From: Martyn White
Sent: 24 June 2019 10:20
To: Amber Willard <Amber.Willard@arun.gov.uk>
Cc: Planning.Responses <Planning.Responses@arun.gov.uk>
Subject: WA/36/19/HH & WA/37/19/L

WA/36/19/HH & WA/37/19/L

Holly Tree Cottage is a Grade II Listed Building which is also located within the Walberton Village Conservation Area.

The application is for the provision of a first floor rear extension, along with a new detached car port/garage structure to be located within the front garden area, to the side of the property. I provide my comments on both elements of the proposal separately.

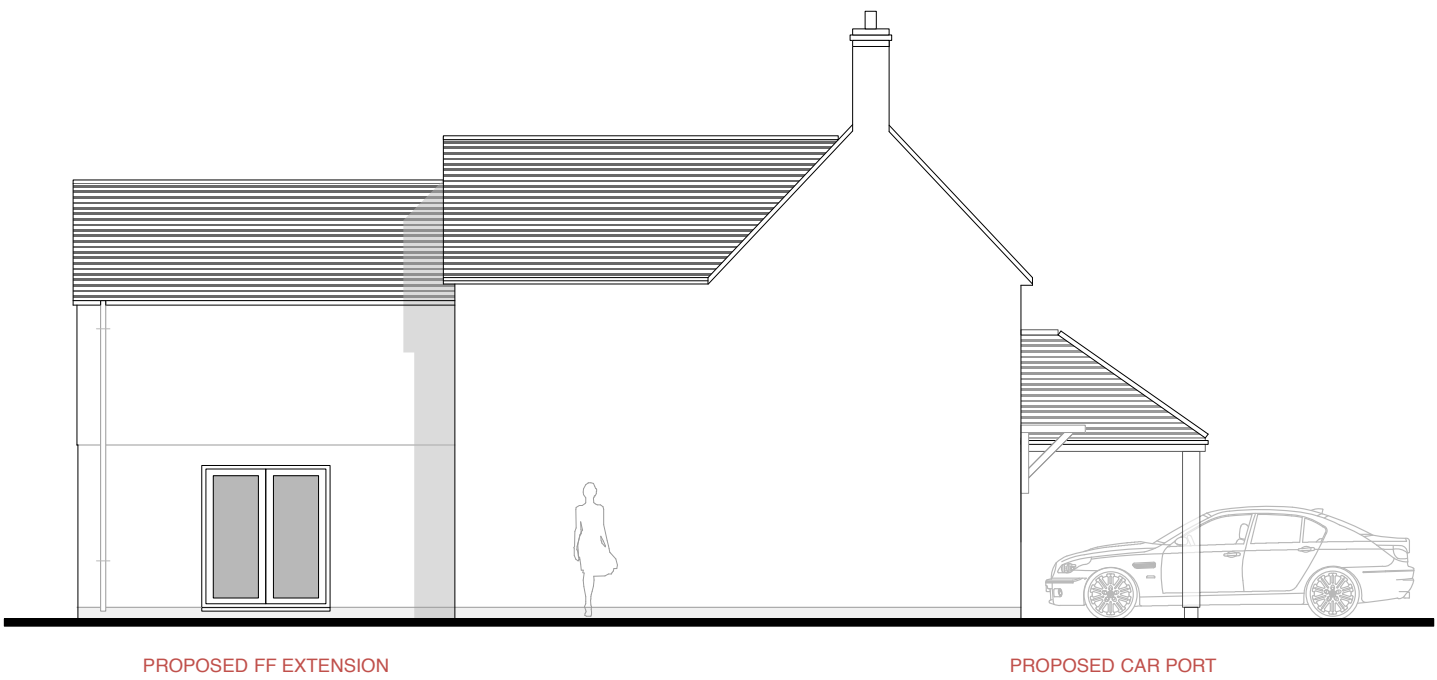
The extension would be sizeable and increase the mass of the existing modern extension. It does not look so be much smaller than the previously withdrawn applications

The current proposal involves the gable end of the proposed first floor extension being below the height of the two historic gables at the rear of the building. This allows for it to read as somewhat subservient to the older parts of the building.

The use of a gable end at first floor level is considered to be acceptable as this is consistent with the use of other gables at the sides and end of the building.

The success of any proposal in this location would depend upon the quality of the materials and windows to be used as part of the proposal.

CLIENT	Mr & Mrs J Waights	SCALE	1:100 @ A3
SITE	Holly Tree Cottage, The Street, Walberton	STATUS	PL / LBC
PROJECT	Proposed First Floor Extension	AUTHOR	AH
DRAWING	001 Existing & Proposed Floor Plans	DATE	23 04 19

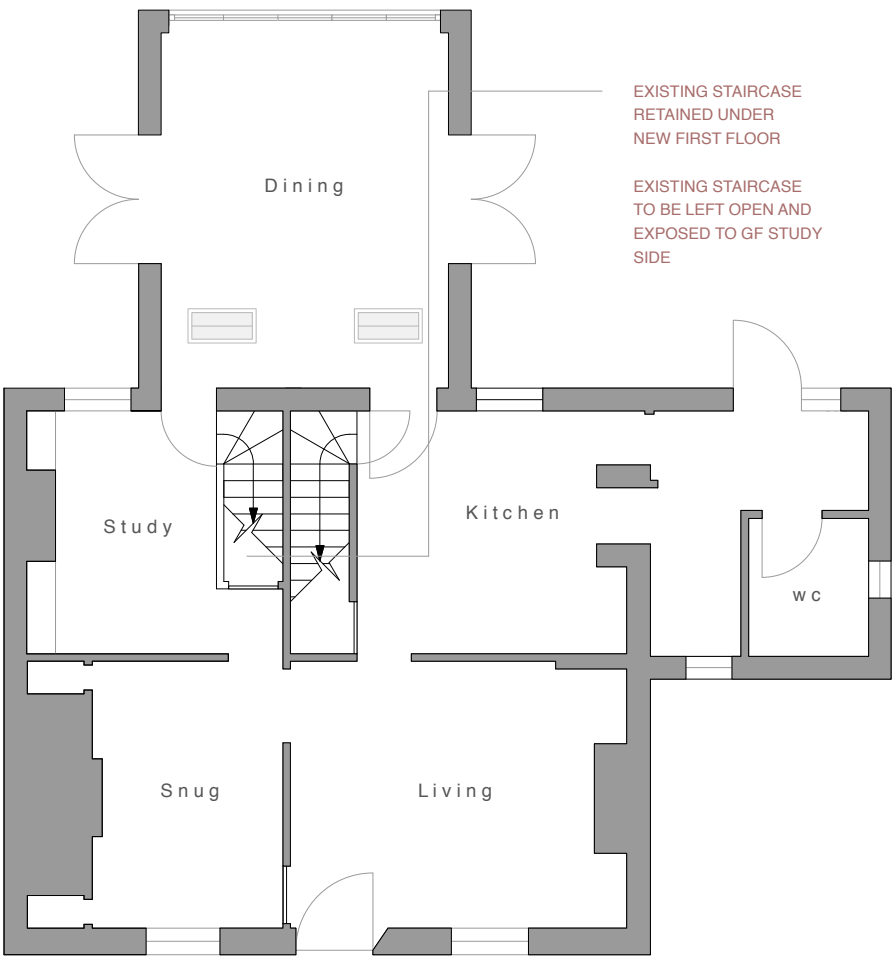
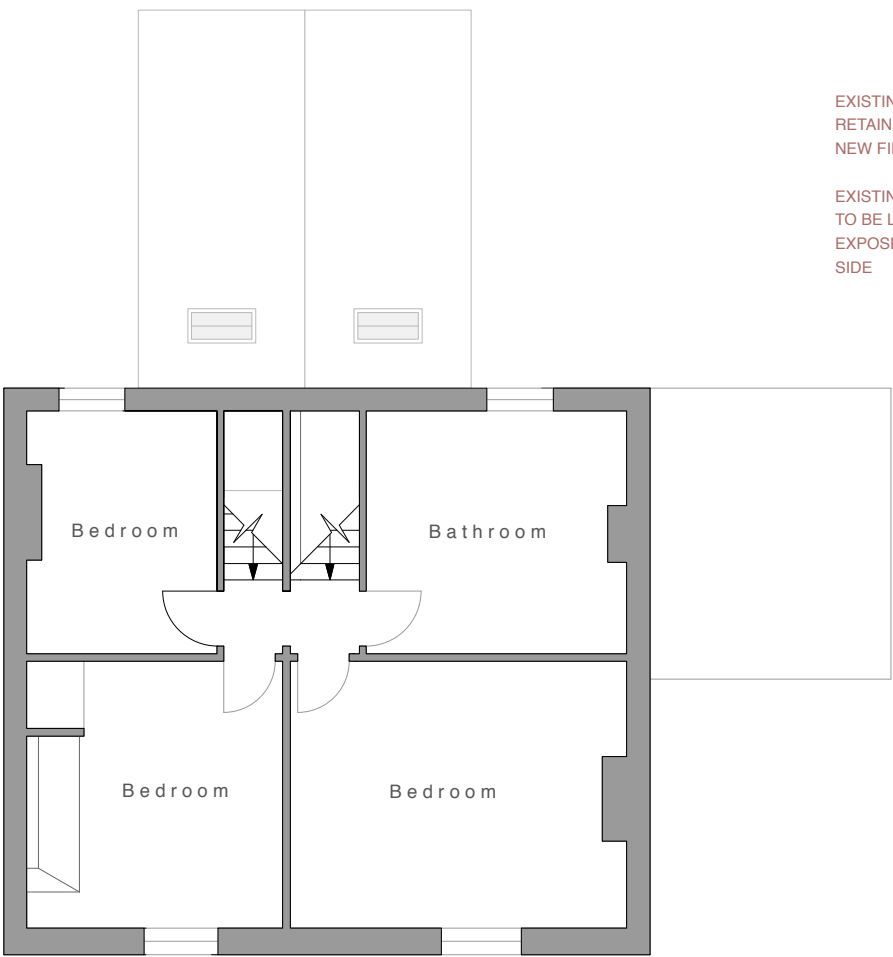
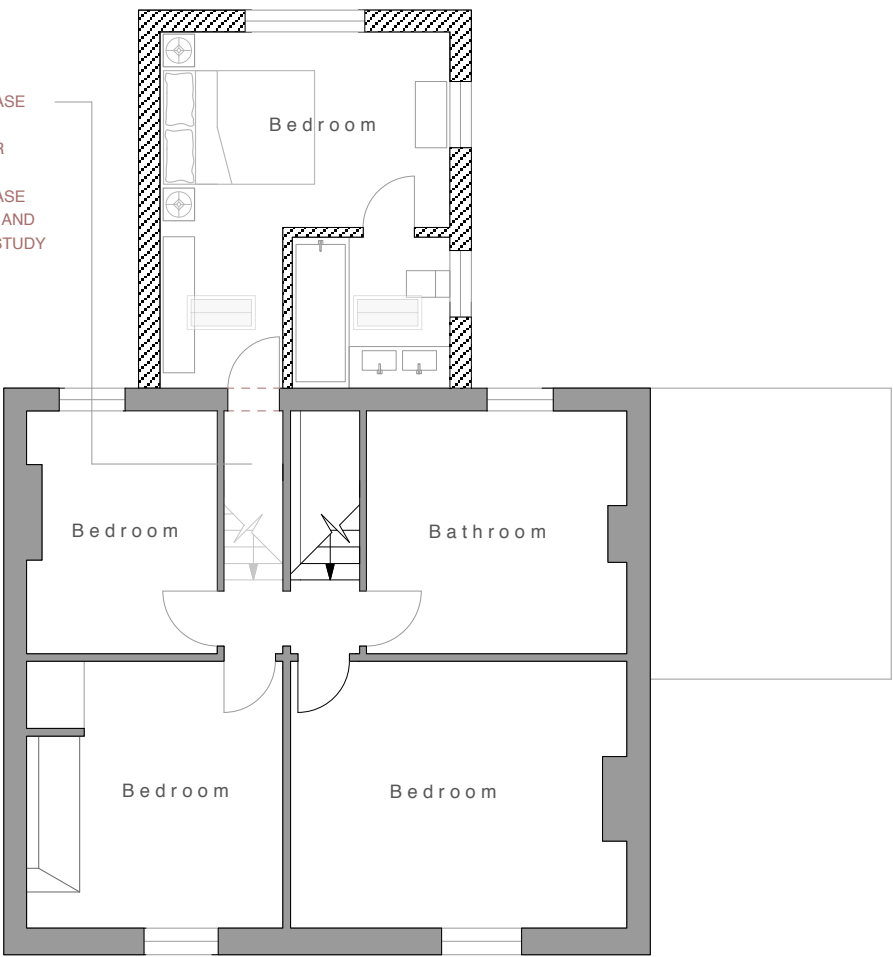
The proposal will involve the loss of one of the existing staircases, which has been identified in the heritage information as being linked to the time when the house was two properties. No further information has been provided regarding the staircase to be removed, or an assessment made on the significance of the structure, nor the impact of its loss. At the moment, it has to be considered that this element of the proposal would result in the loss of historic fabric, remove an element of the properties historic development and could therefore harm the significance of the cottage.

CLIENT	Mr & Mrs J Waights	SCALE	1:100 @ A3
SITE	Holly Tree Cottage, The Street, Walberton	STATUS	PL / LBC
PROJECT	Proposed First Floor Extension	AUTHOR	AH
DRAWING	002 Proposed Garage & Roof Plans	DATE	23 04 19

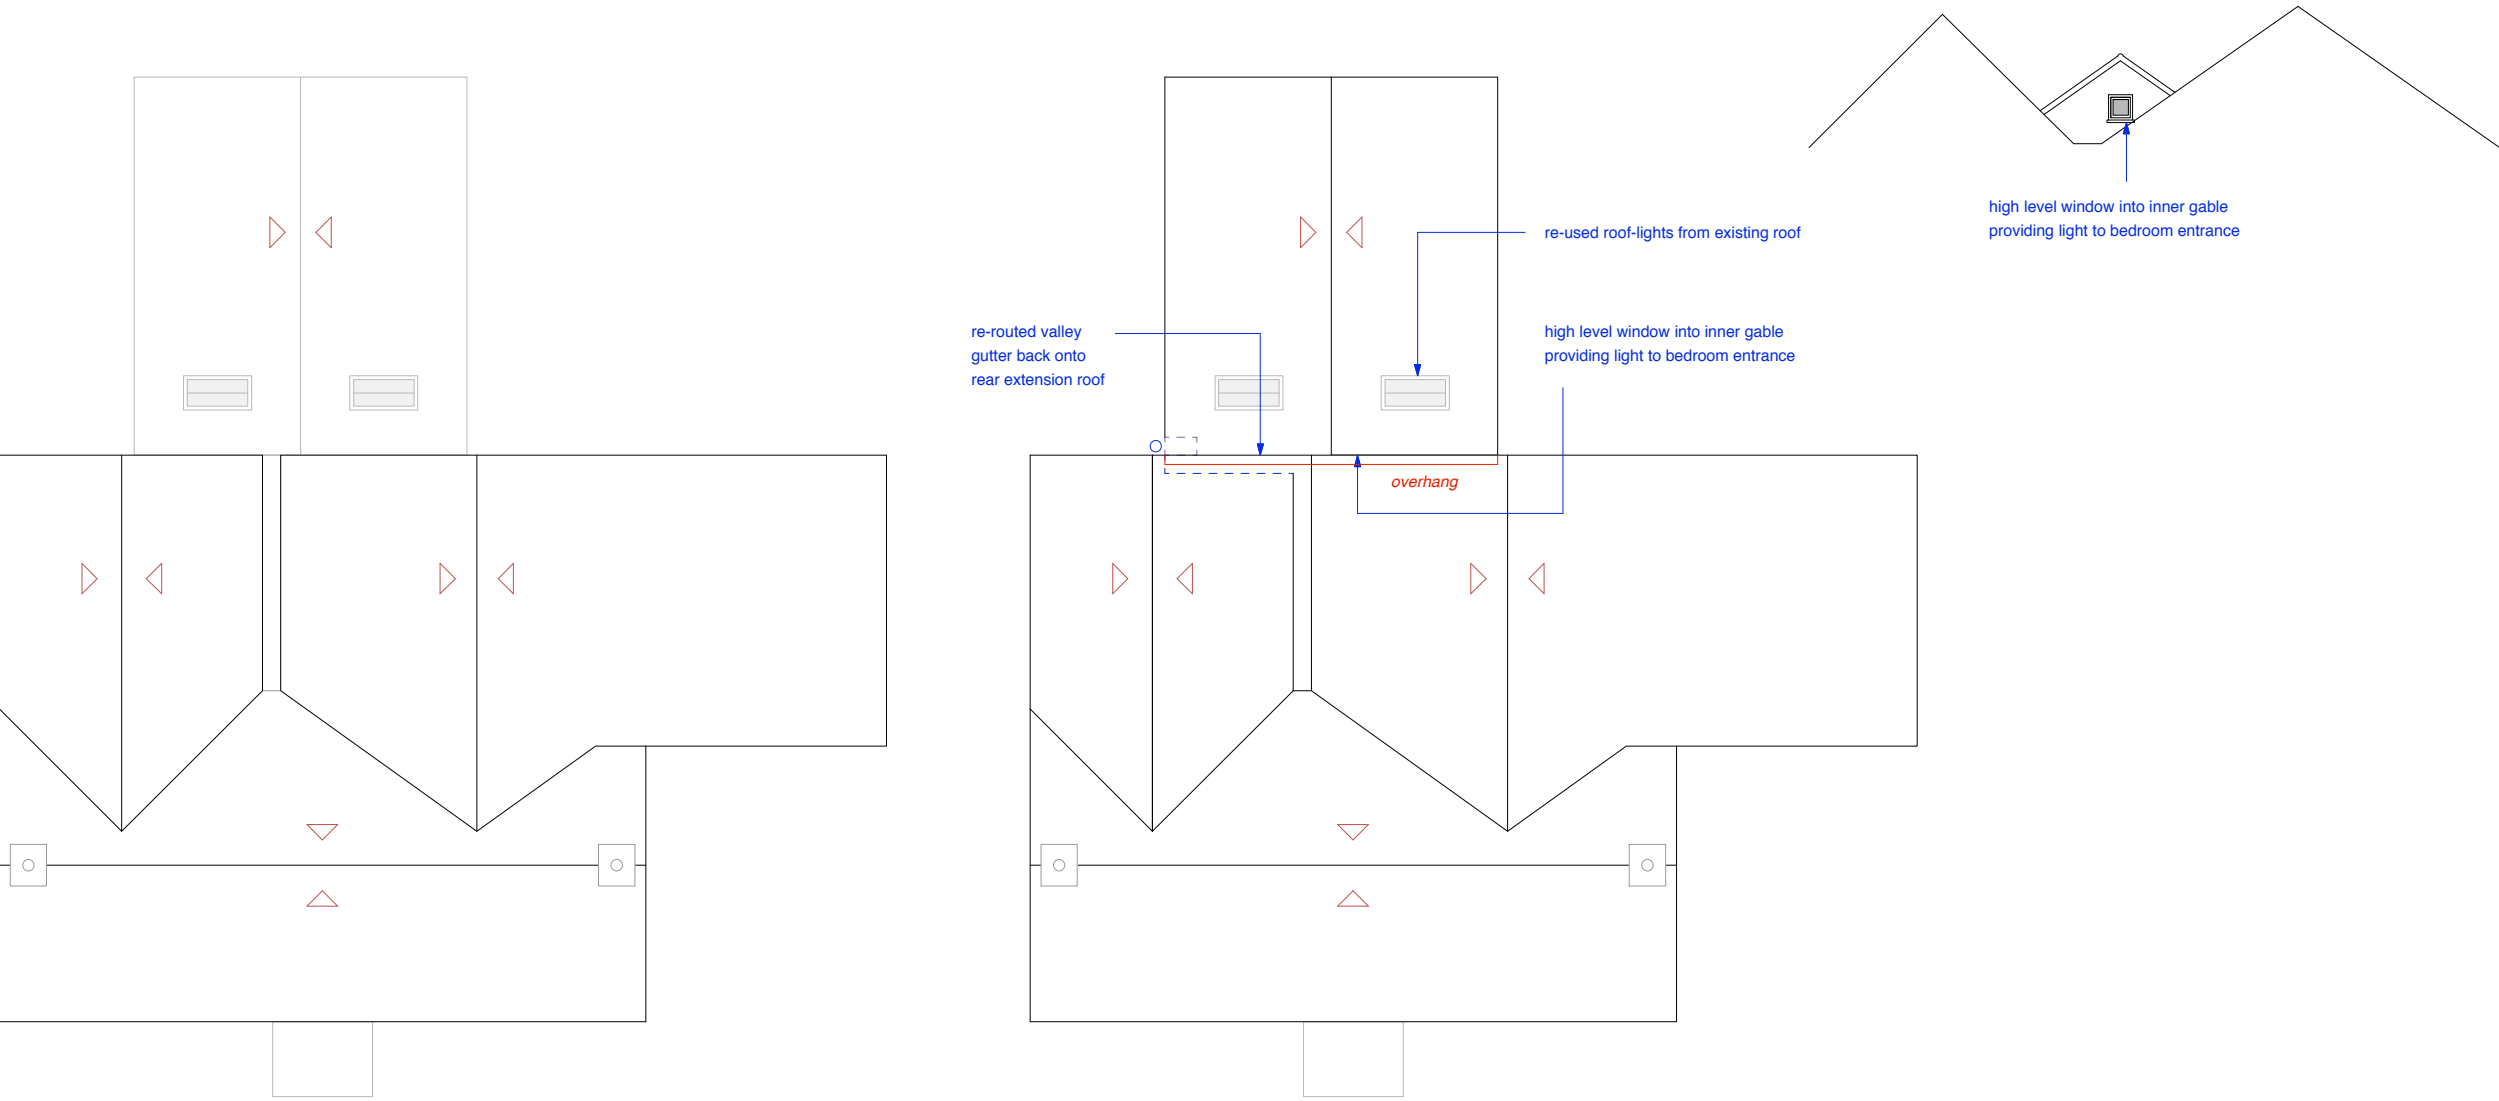
The proposed carport would essentially project forward of the front elevation of the cottage on part of the existing parking area. At present the front garden area is contained by the flint wall and mostly laid to lawn with a small parking area for the resident's private car. Therefore, at present the cottage is fully visible from the street, and forms a focal point.

Development of the garage in this particular location will mean that it will play a dominant role in the street-scene and partially block views of the listed cottage, so that only part of it is visible when looking westwards.

Further, it would be the only structure of this design, in this location in the conservation area.
